# **RESPONSE TO SUBMISSIONS REPORT**

90-102 Regent Street SSDA

**THE TRUST COMPANY (AUSTRALIA) LIMITED ATF  
WEE HUR REGENT TRUST**

1 March 2020

The City of Sydney Awnings Policy 2000

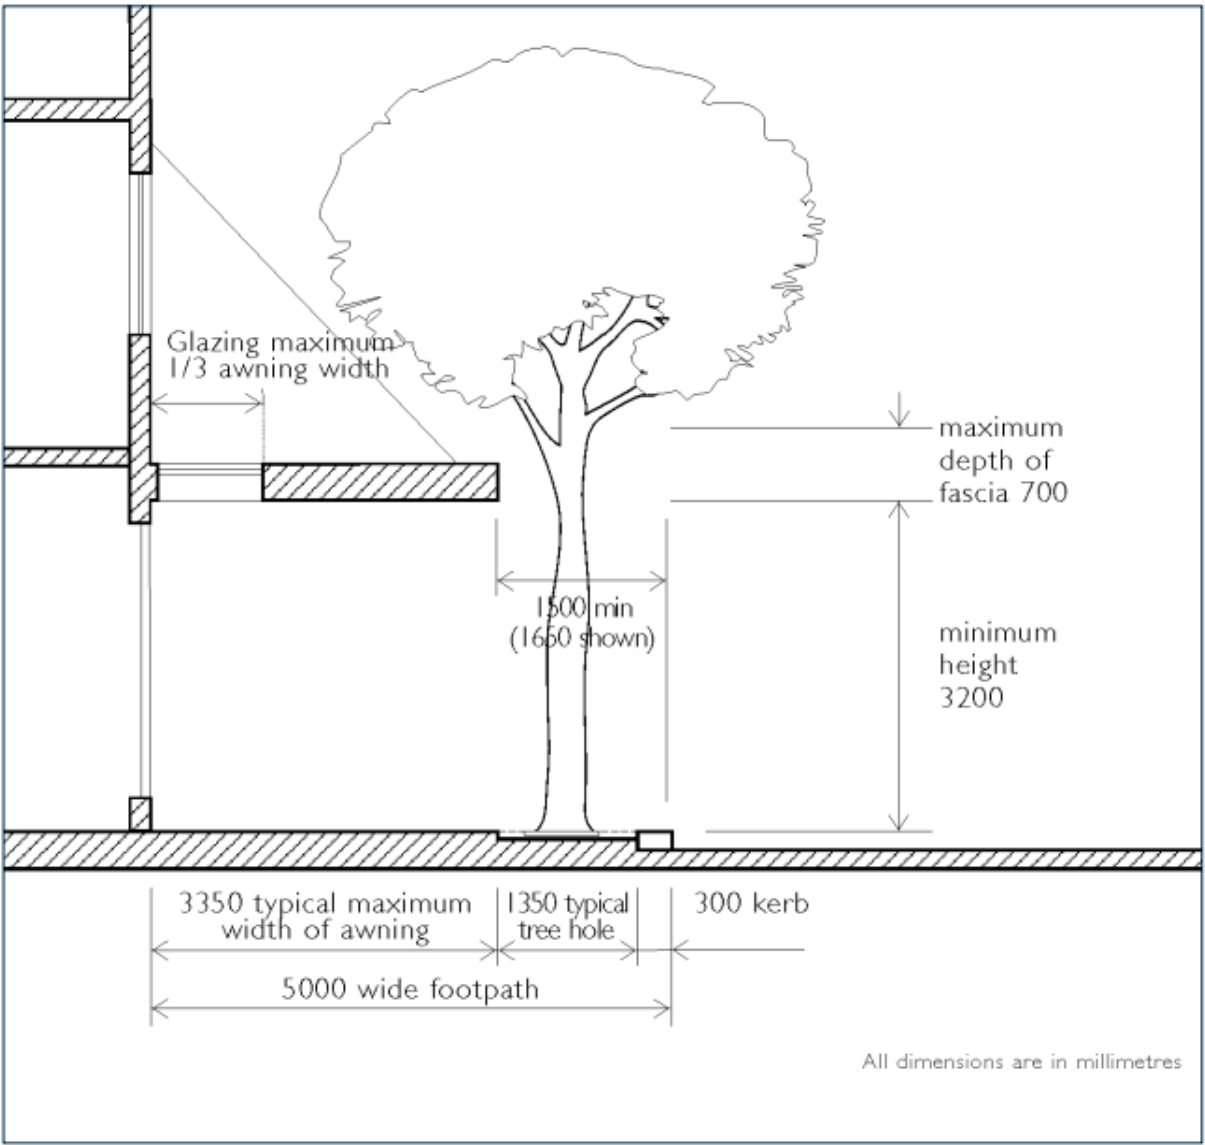
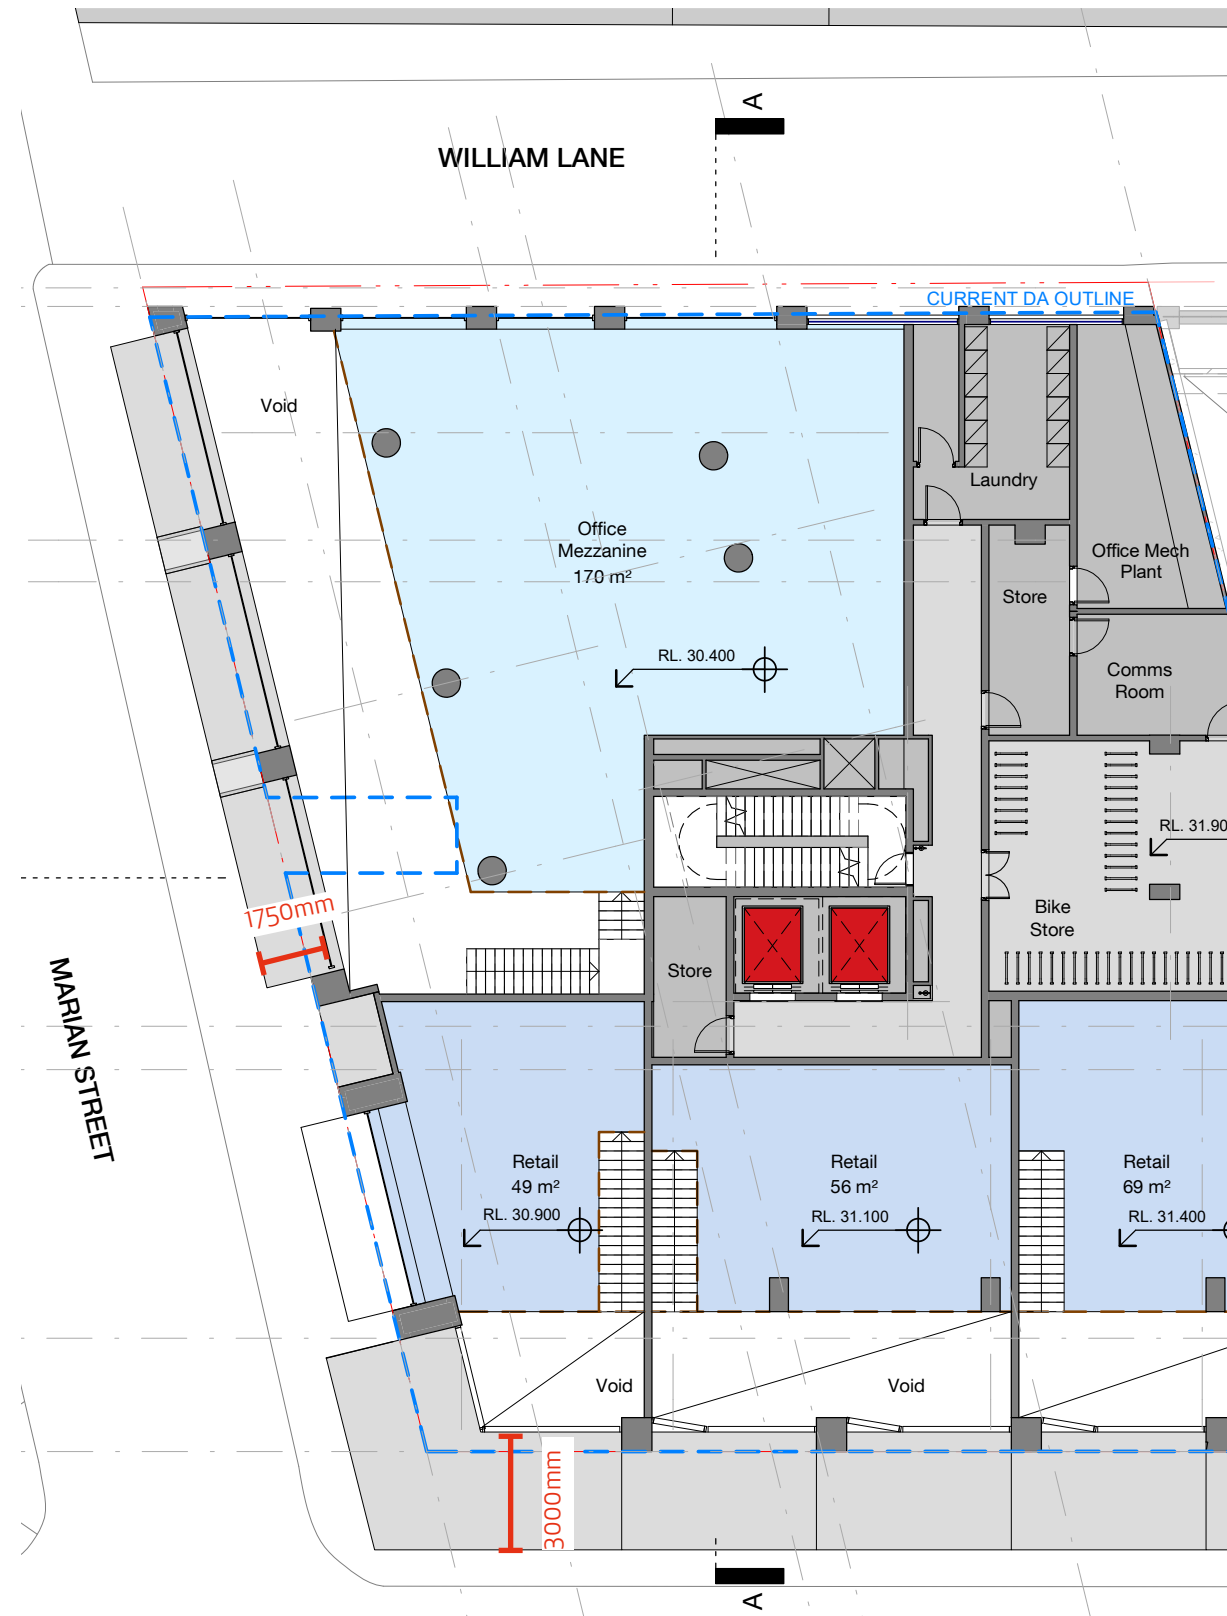
- **Building design:** The City of Sydney (CoS) requested the awning design be amended to provide effective weather protection from rain, sun and wind. It was also requested adequate space and clearance be provided for new street trees to grow without conflicting with the awning (refer public domain and landscape below).

WIND MITIGATION

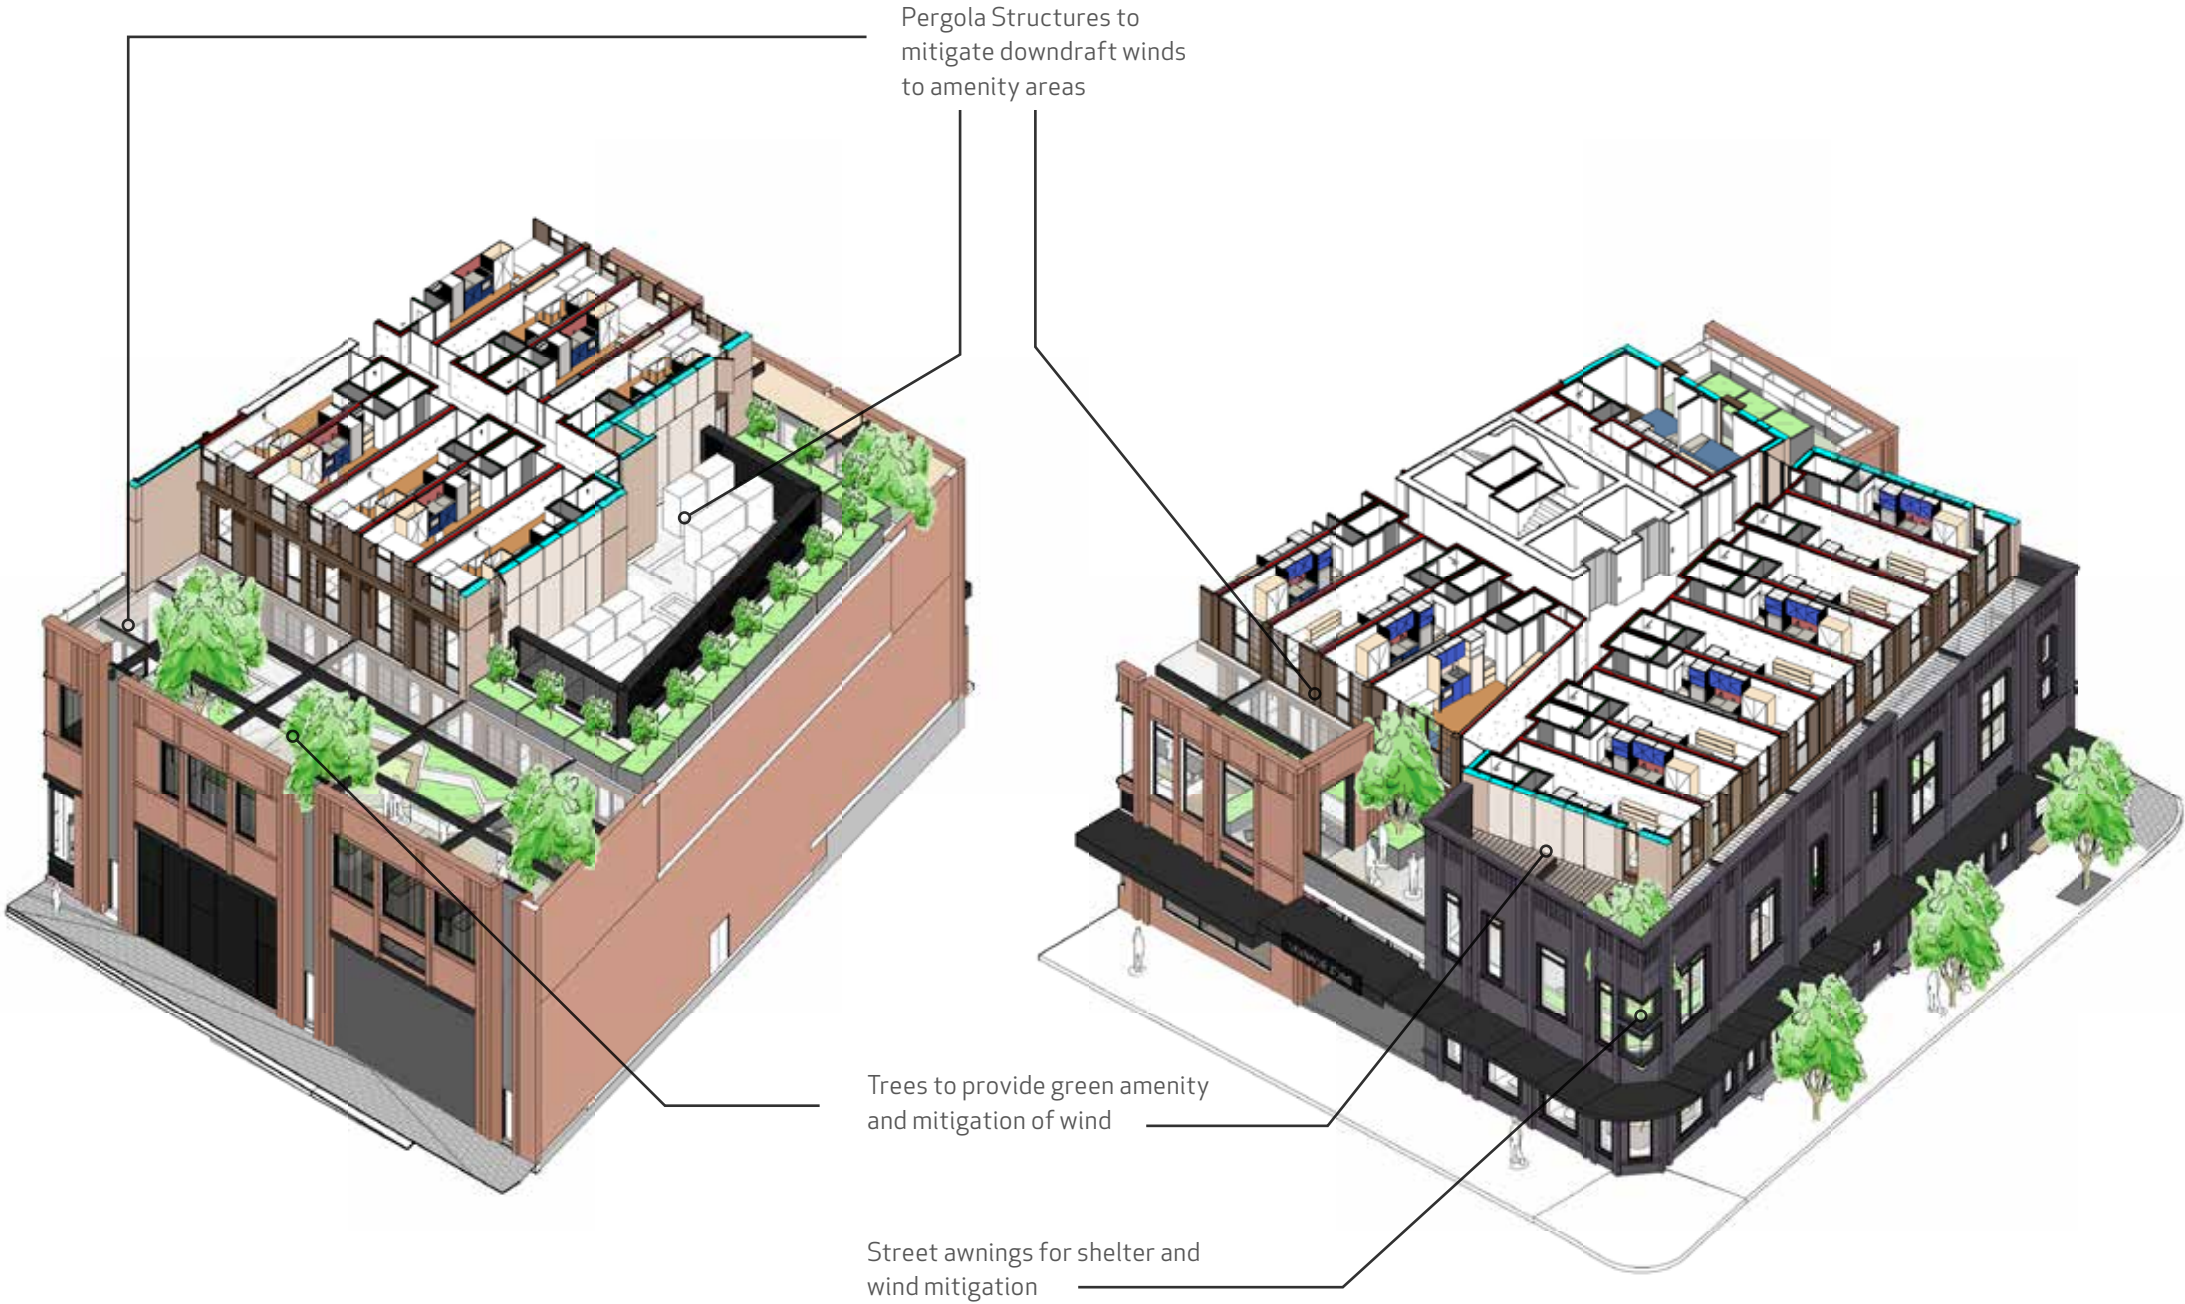
- **Wind impacts:** the CoS raised concerns regarding the potential wind impacts and the adequacy of the proposed mitigation measures to achieve an appropriate level of amenity.
- **Overshadowing:** D&A Markakis and other anonymous public submissions raised concerns about overshadowing to the St Luke's Church and the surrounding development.
- **Safety and security:** NSW Police – South Sydney Police Area Command provided recommendations for CCTV, clear lighting and signage. A public submission raised safety concerns associated with the laneways.
- **Ecologically Sustainable Development (ESD):** The CoS raised concerns regarding the level of detail regarding the ESD measures to be included in the design and construction of development.

REVISED PLAN - LOWER GROUND LEVEL

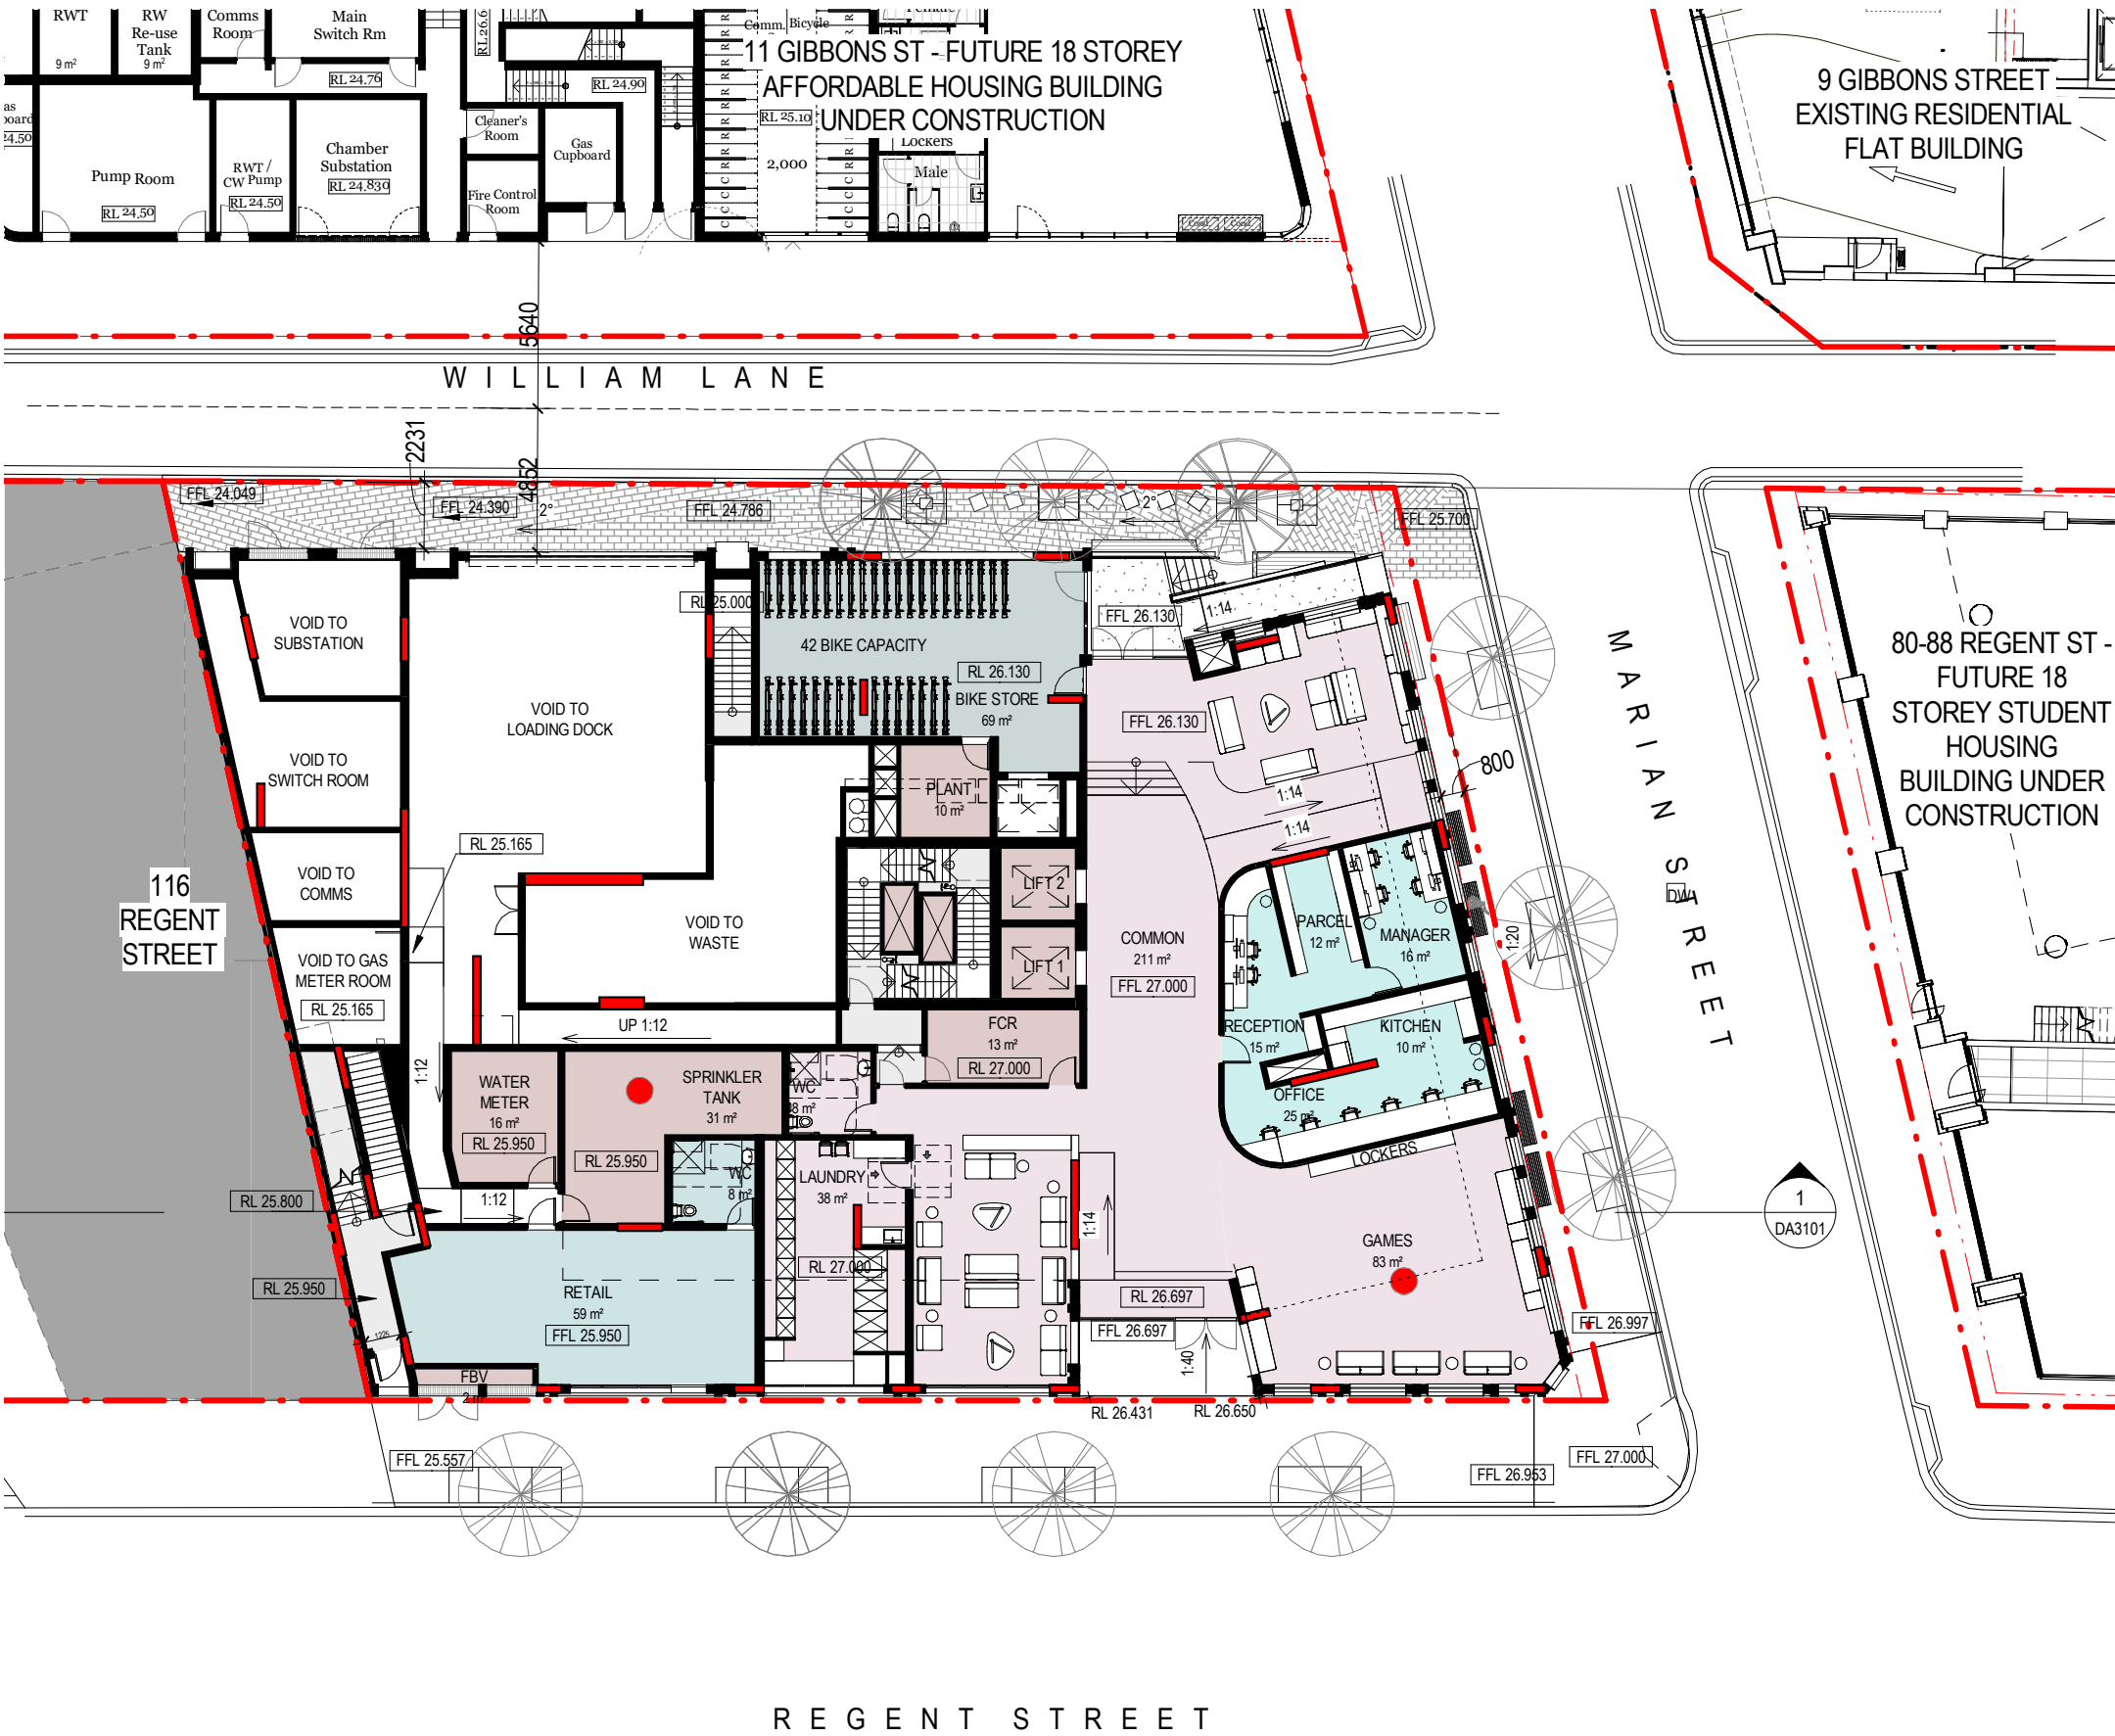
- **Transport and Access:** TfNSW and CoS requested additional information on the proposed loading facilities. TfNSW also requested conditions of consent regarding the Green Travel Plan and Transport Access Guide. Submissions from the public raised concerns regarding the adequacy of the on-site parking arrangements, as well as the potential cumulative impacts associated with construction traffic and parking.

TTPP Planning have prepared a Transport Planning Memo (**Appendix S**) to address the Transport for NSW and CoS submissions. The loading dock and associated back of house spaces have been relocated further south of the site, to better address egress pathways and serviceability requirements. Swept paths have been subsequently reviewed and confirms the proposed turntable strategy for trucks to enter front in and front out.
